A46 Newark Bypass

Scheme Number: TR010065

Statement of Common Ground with Historic England

**Statement Of Common Ground with
Historic England**

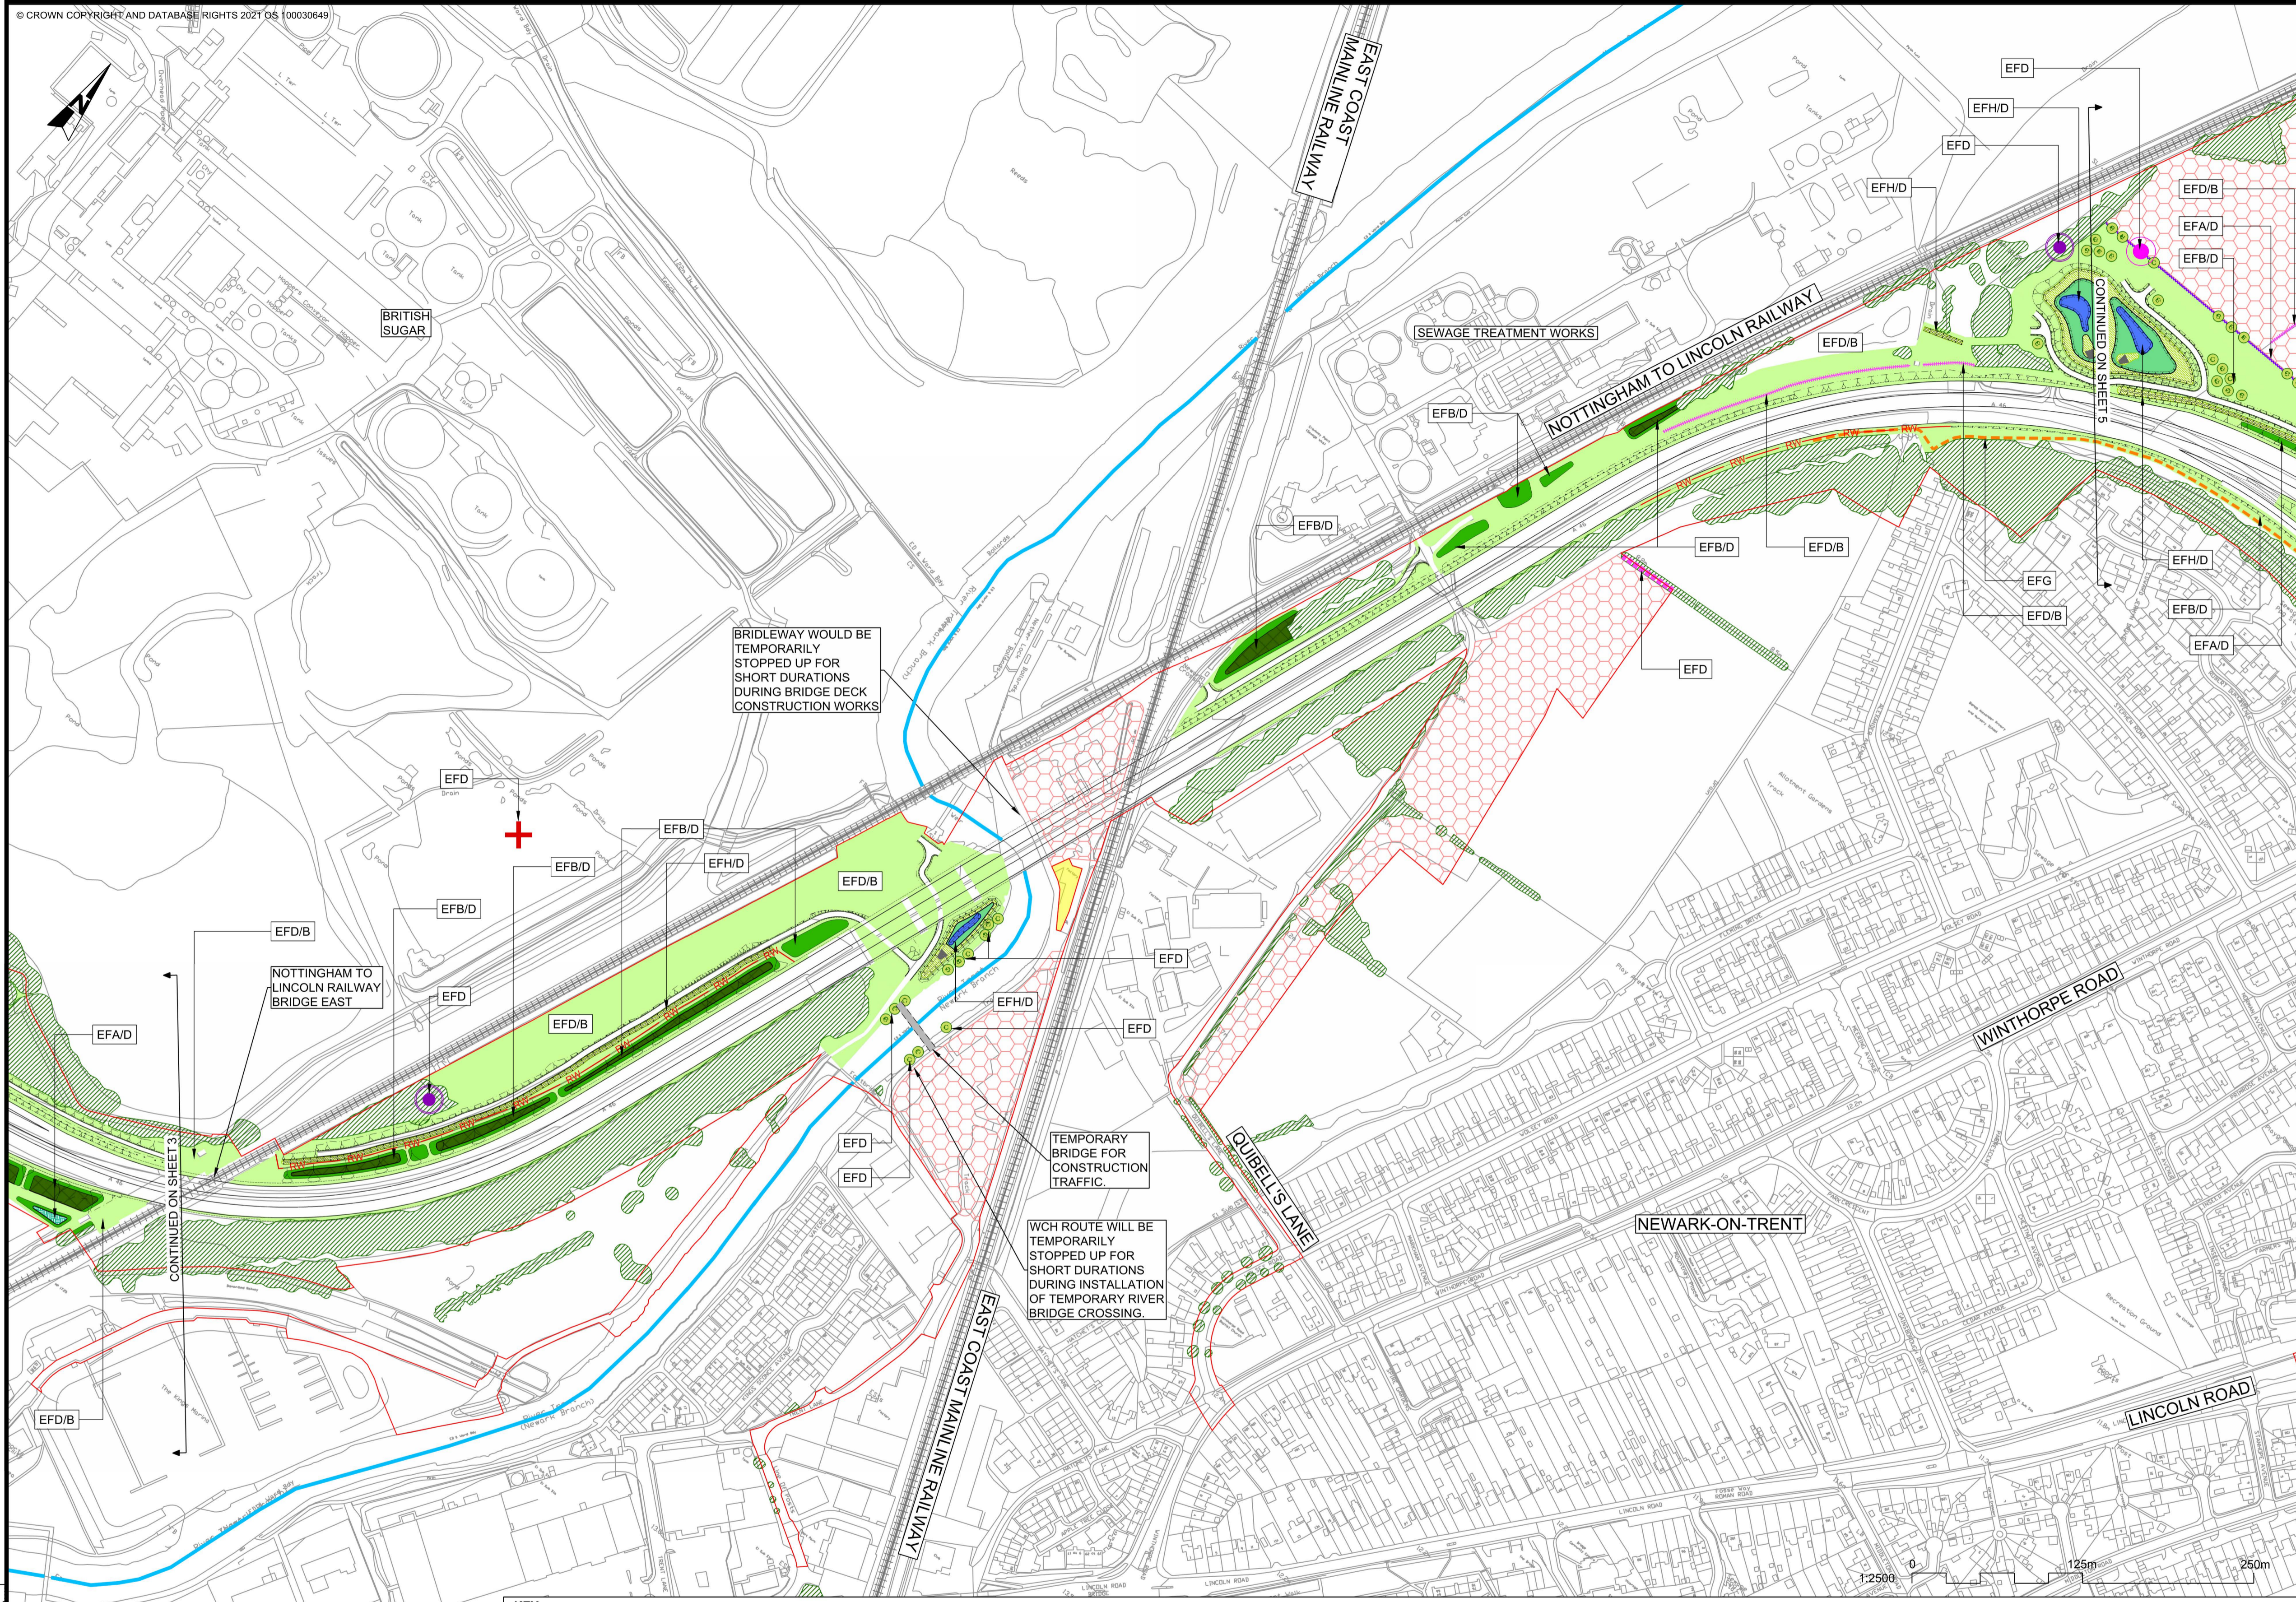
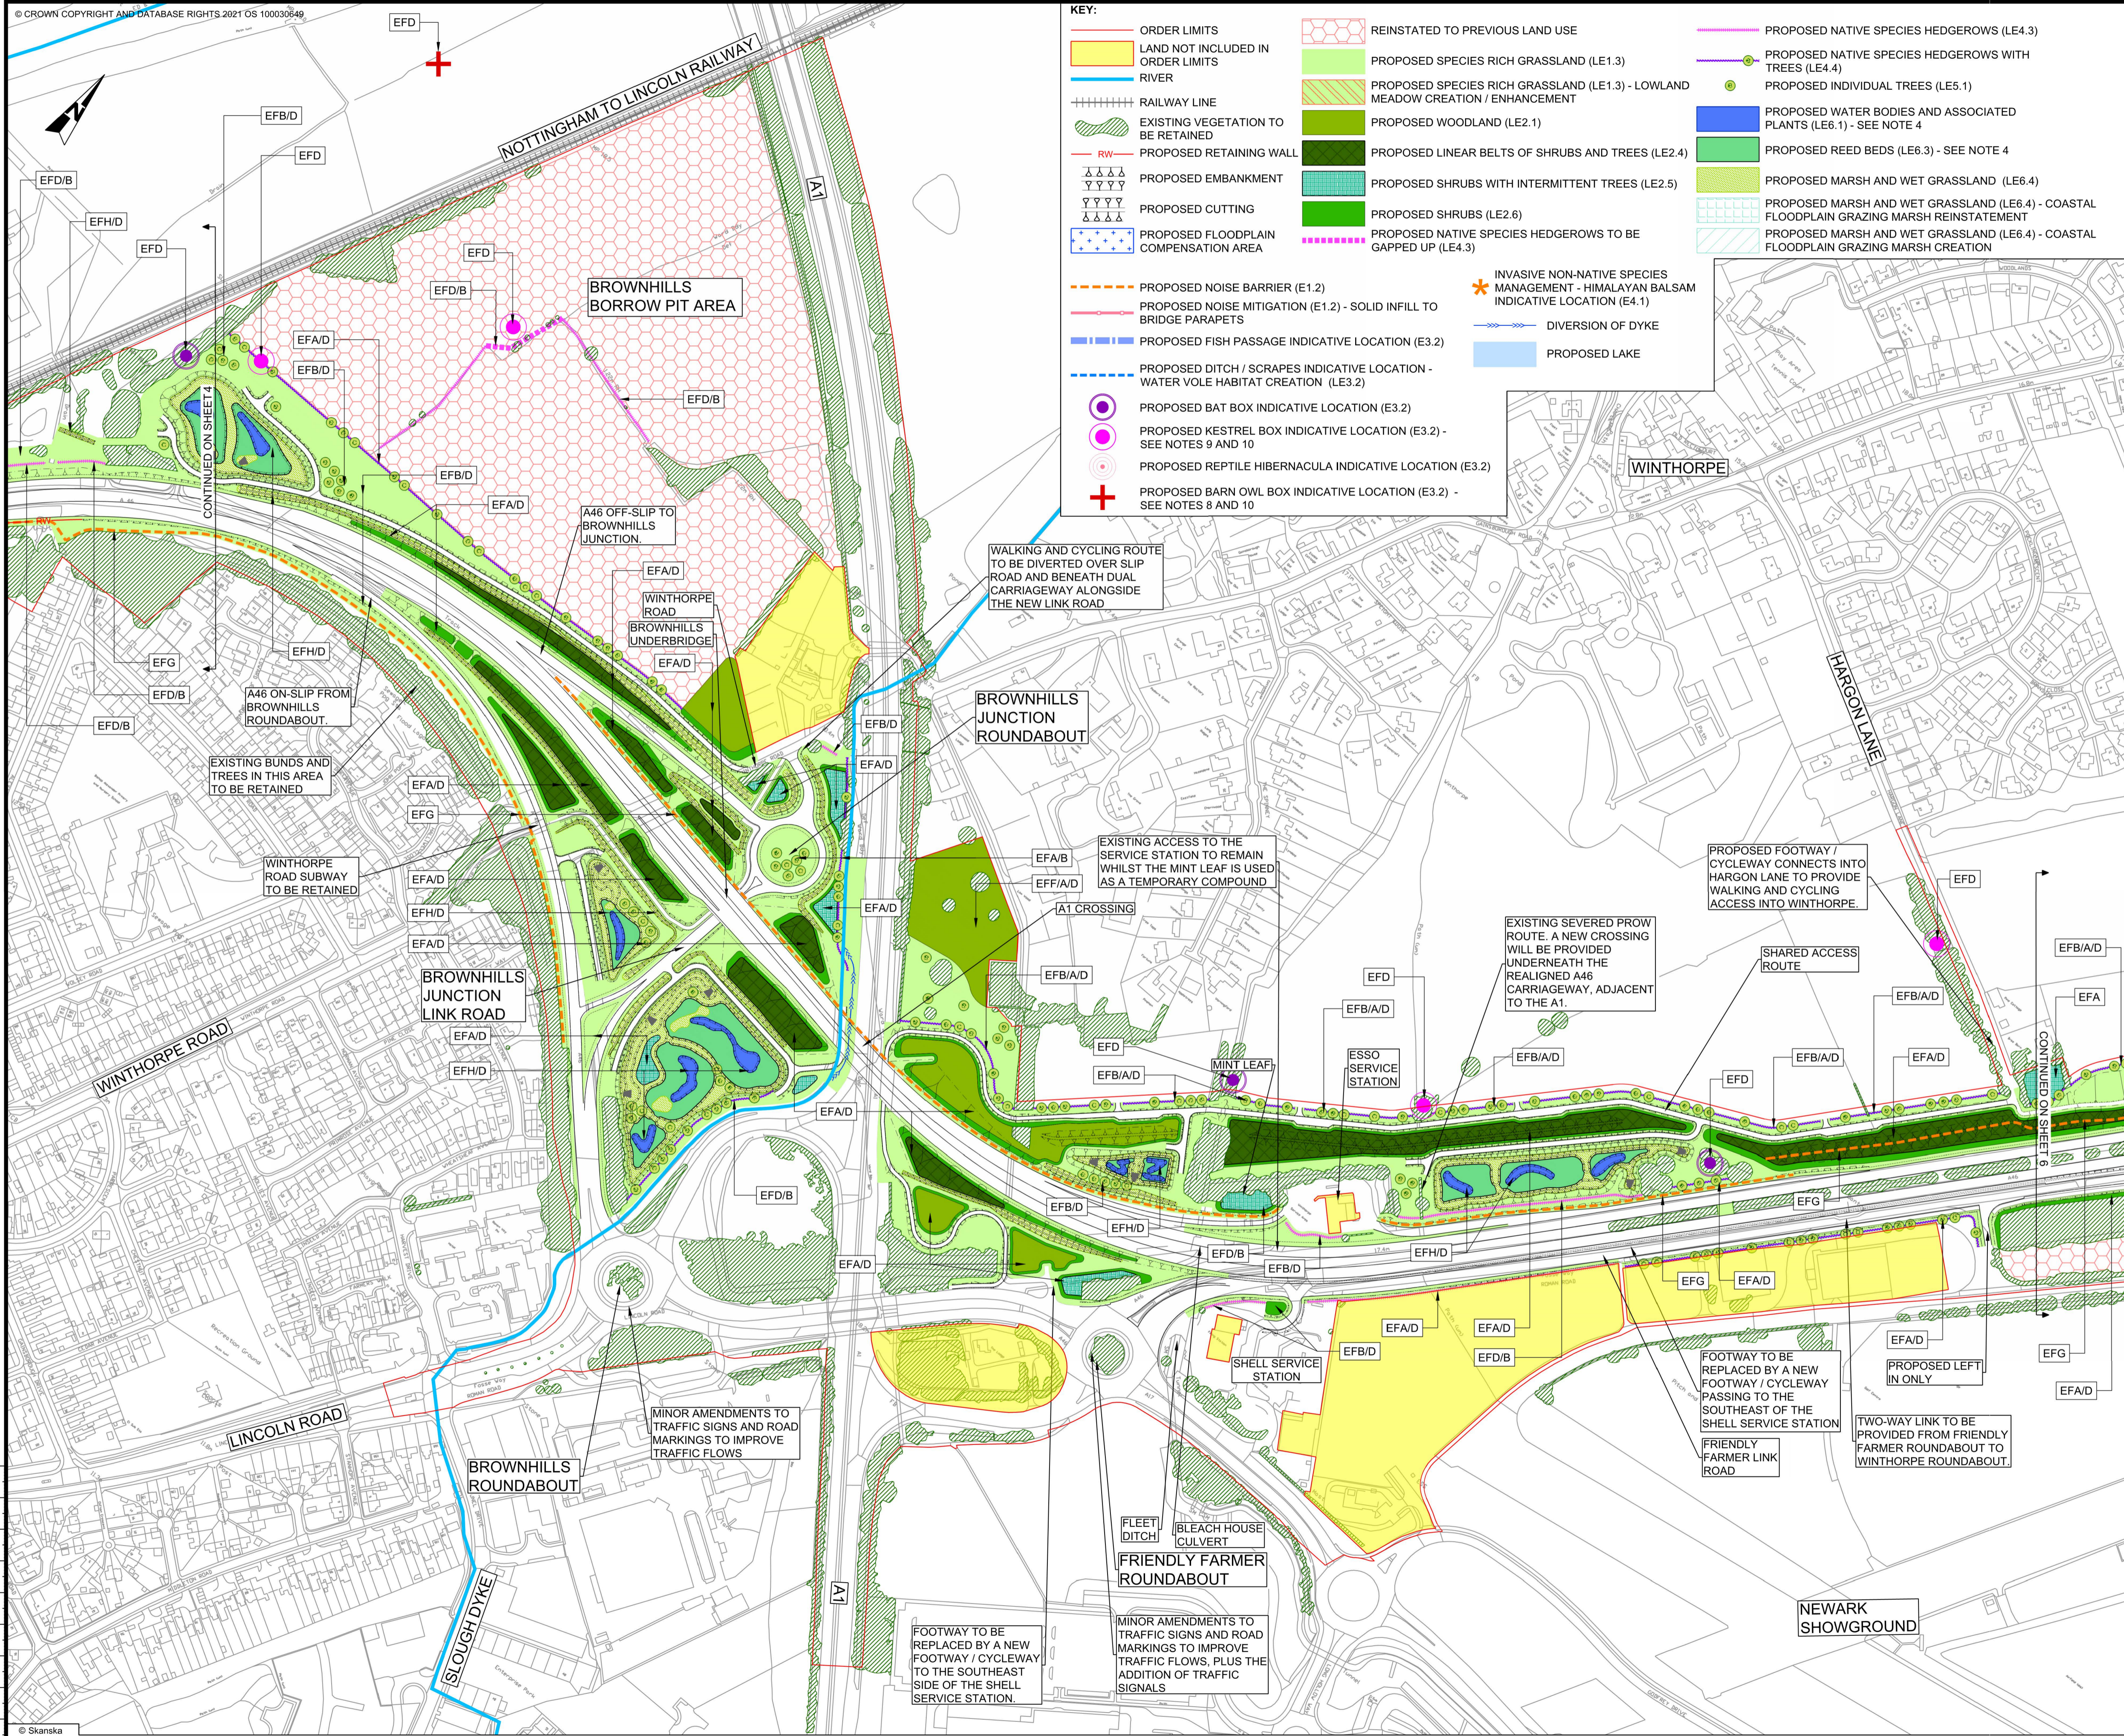
13.	Langford Hall – new approach road and entrance gates	Figure 2.3 (Environmental Masterplan) of the Environmental Statement Figures [AS-026]	<p>Meeting with Historic England 11/10/2024:</p> <p>Understand rationale behind linear route for new driveway between new proposed entrance and location where it meets the existing driveway. This route avoids historic copse of trees at original end of the driveway. The direct line approach meets the existing driveway at a natural break in the trees.</p> <p>Agree that there is no clear rationale, or extra benefit to creating a faux curvilinear approach in this location.</p> <p>Agree that meeting the existing driveway at the proposed location, ensures that the gradual 'reveal' of the main house is retained and conserved.</p> <p>Discussed requirement for new entrance to 'speak to' the architecture of the Langford Hall, and to serve its purpose of ensuring visitors and passers-by that this an entrance to an important property.</p> <p>Also discussed the importance of the design of any gates, piers, railings, to be a 'foretaste' of the architectural style of</p>	<p>Routes to the north of the proposed landscape bund in order to join at location of lodge were considered but had no clear rationale and would result in impacts to habitats through destruction of a historic copse of trees.</p> <p>Proposed linear route from existing field gate, directly to natural break in historic tree-line is a clear choice, and ensures sense of reveal and arrival afforded by existing driveway is retained and maintained.</p> <p>Proposed new driveway will have avenue tree planting, in line with existing parkland/estate entrance characteristics, as outlined in Figure 2.3 (Environmental Masterplan) of the Environmental Statement Figures [AS-026].</p> <p>The Applicant agrees with Historic England's position with regards to design and detailing pillars/gates/railings for the entrance.</p>	Agreed	11/10/2024

Issue No	Issue	Document reference	Historic England's Position	Applicant's Position	Status	Date status confirmed
			<p>the main house – not detailed as a pastiche of work elsewhere, but – appropriate in scale, neo-classical proportion and design, of good quality, natural materials, including brick, stone, lime mortar, estate railings etc, matching the pallet of the house to ensure quality of finished design, and its execution by an appropriately skilled specialist (sub) contractor.</p>
